From: Anita Gardner <Anita.Gardner@arun.gov.uk>
Sent: 03 June 2020 13:35
To: Planning.Responses <Planning.Responses@arun.gov.uk>
Subject: FW: LY/4/20/PL Barn at Broomhurst Farm, Lyminster

From: Info @ Folkes Architects [REDACTED]
Sent: 03 June 2020 11:14
To: Anita Gardner <Anita.Gardner@arun.gov.uk>
Cc: D HARRIOTT [REDACTED]
Subject: RE: LY/4/20/PL Barn at Broomhurst Farm, Lyminster

Please find attached a copy of the revised site plan, drawing number 20011/2.01 revision C and drawing 2.02 revision A. I would be grateful if you could substitute these for the previous versions.

DRAWING TITLE
**Existing Location and Block Plan
PLANNING ISSUE**

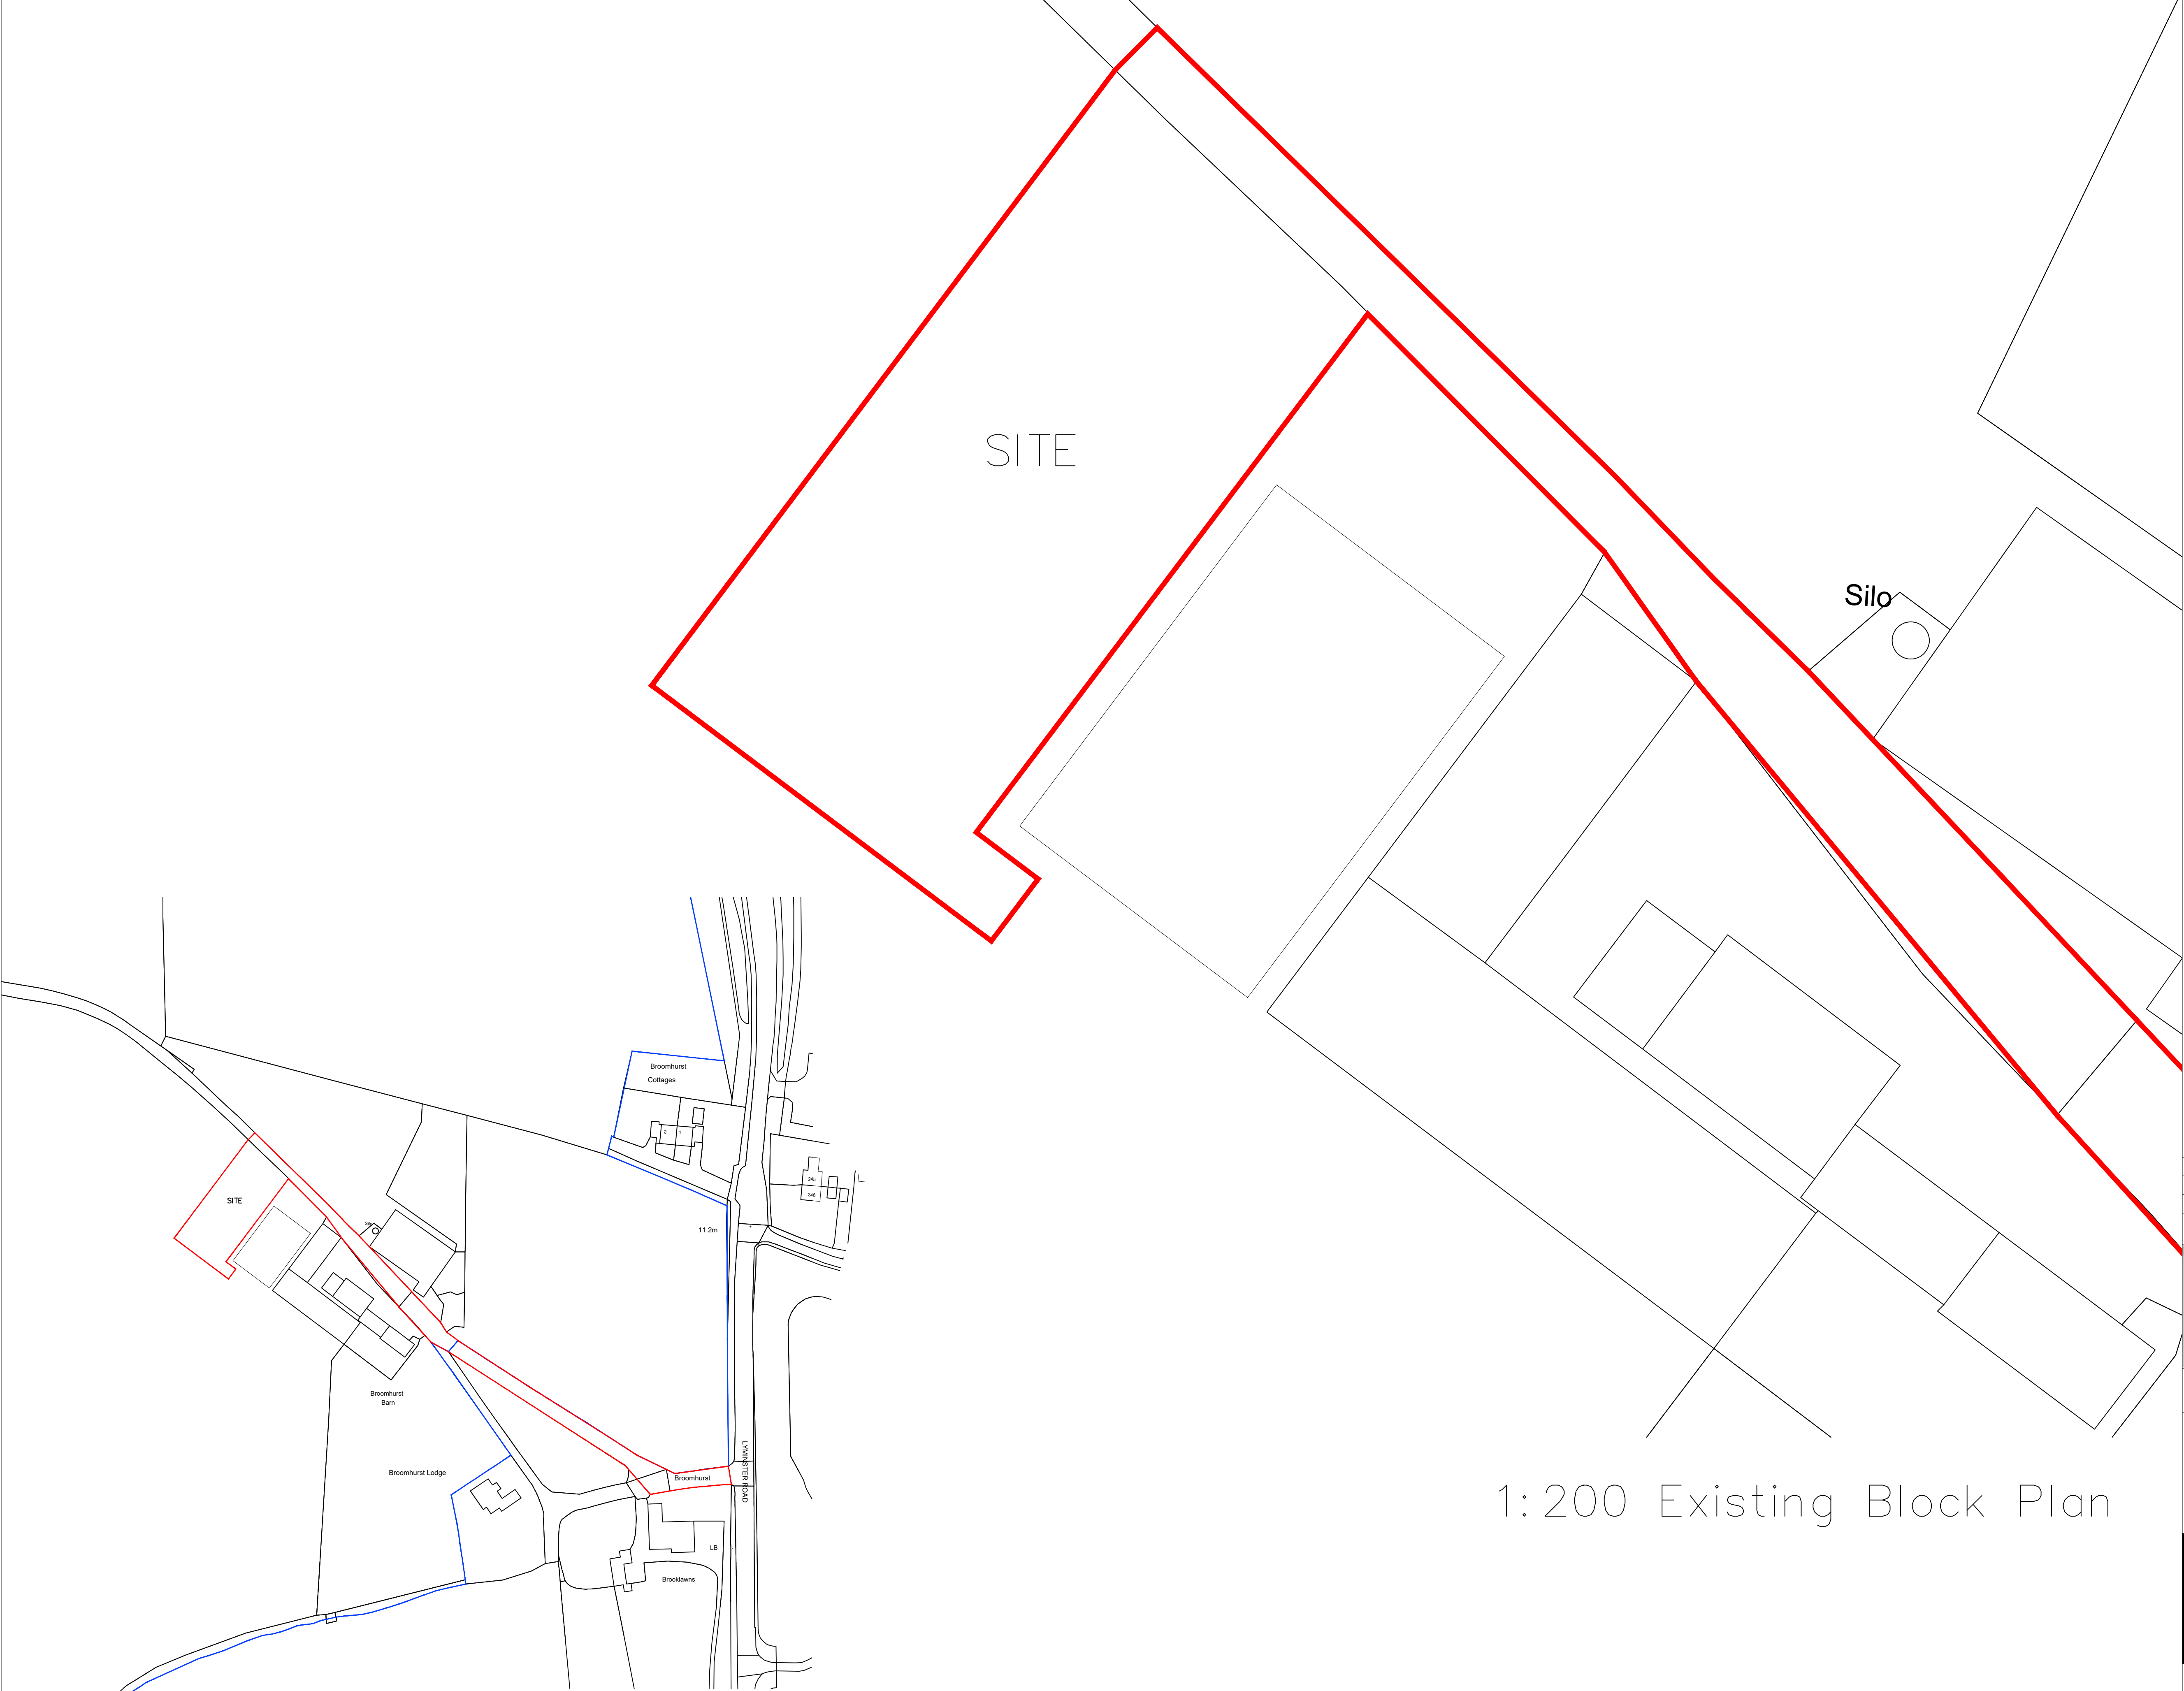
Please can you let me have a revised site plan and elevation plan indicating native tree planting along the southern boundary as discussed, by Wednesday next week?

Is there no option to reduce the width/length of the building slightly so that tree planting can be included within the red edge? Or to move the building forward or sideways within the red edge? A reduction in size would help to address our concerns and those of the Parish.
